Objection to Planning Application - 3/2026/0172 – Proposed erection of a detached dwelling with single garage and store – Land to rear of Pimlico House, Gisburn Road, Gisburn BB7 4ES

Front (West) Elevation

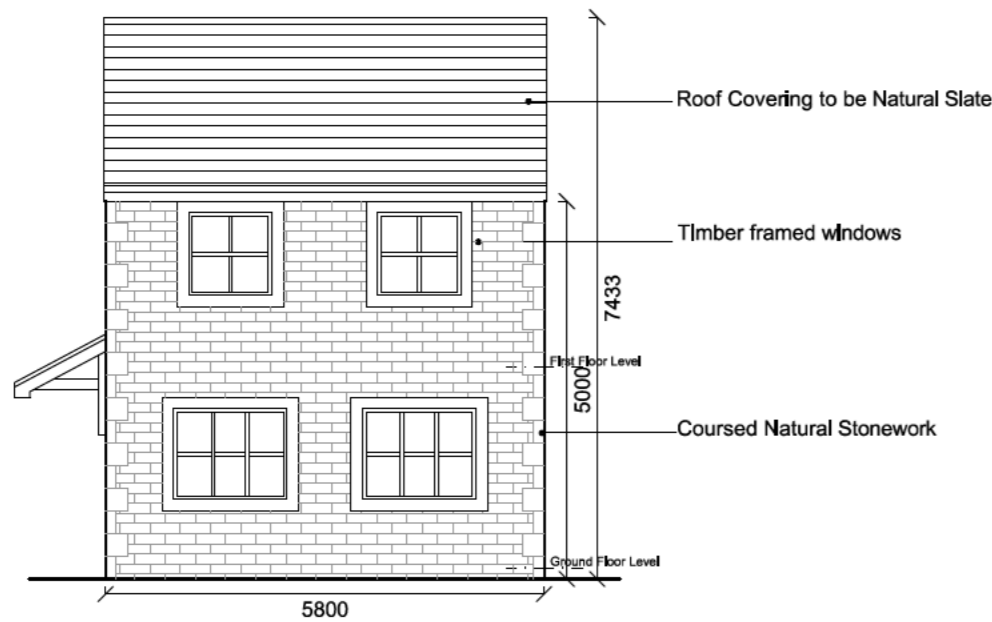
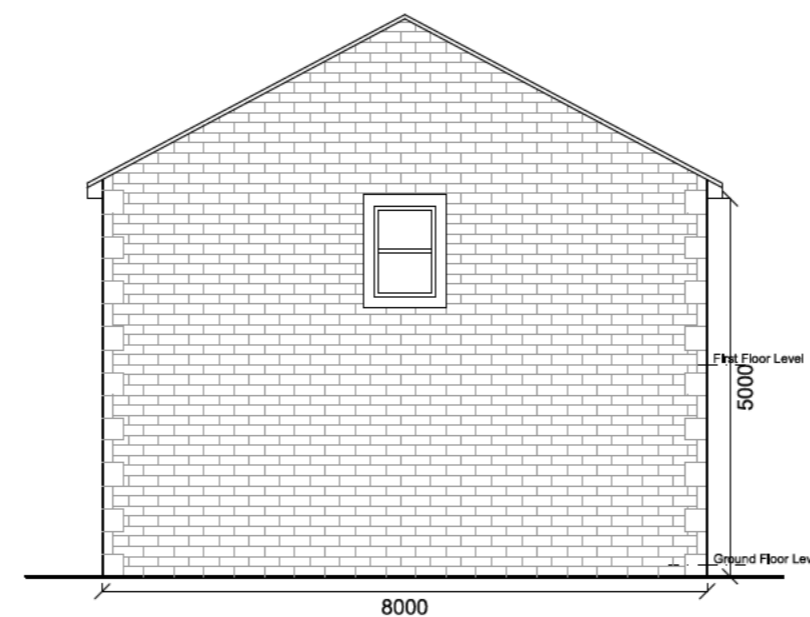
Previously, when Duckworth's had a building on the site it was a single storey building. This proposal is for a two storey property. The proposed property will take light from the [REDACTED] and [REDACTED] areas of our property and will remove the view and light from our [REDACTED] (which [REDACTED] the site). There will be an impact on our privacy which we have not had previously. We have never had neighbours to the [REDACTED] of our property, and in fact, chose this property for that very reason. This would therefore represent a loss of amenity for us.

We have always enjoyed a light and open countryside view from our landing window as previously there was only a single storey building to the side. What is being proposed for us is a view onto a "gable end" of a large stone building which, from our front garden, will be particularly imposing. This removes the amenity of view and light which we have quietly enjoyed for [REDACTED]. There has never been a two storey building on this site. The proximity of this overbearing gable end to the [REDACTED] of our property is an obvious concern to us. This new proposal now also includes a door and window in the gable end which will face [REDACTED] property. This will remove privacy to the [REDACTED] of our property. A drive and garage immediately on the [REDACTED] will bring unnecessary noise and disturbance to our [REDACTED] and [REDACTED] areas and below our [REDACTED] and [REDACTED]. Coming out of our [REDACTED] to look at a stone gable end of a two storey house which has not existed before overshadowing our [REDACTED] and blocking our rural views causes a loss of the amenities of peace, quiet and privacy.

The proposed street elevation on the plans appears to be stretched and gives the impression of space around this building – I don't believe that is the case. Mr Wilsons proposal says that this

application will allow sight into the conservation area of Pimlico House and surrounds, but in reality, most of the view will be blocked by the 2 storey house. Where the garage is proposed there is no view of Pimlico House so nothing has been gained (only that [REDACTED] to my [REDACTED]).
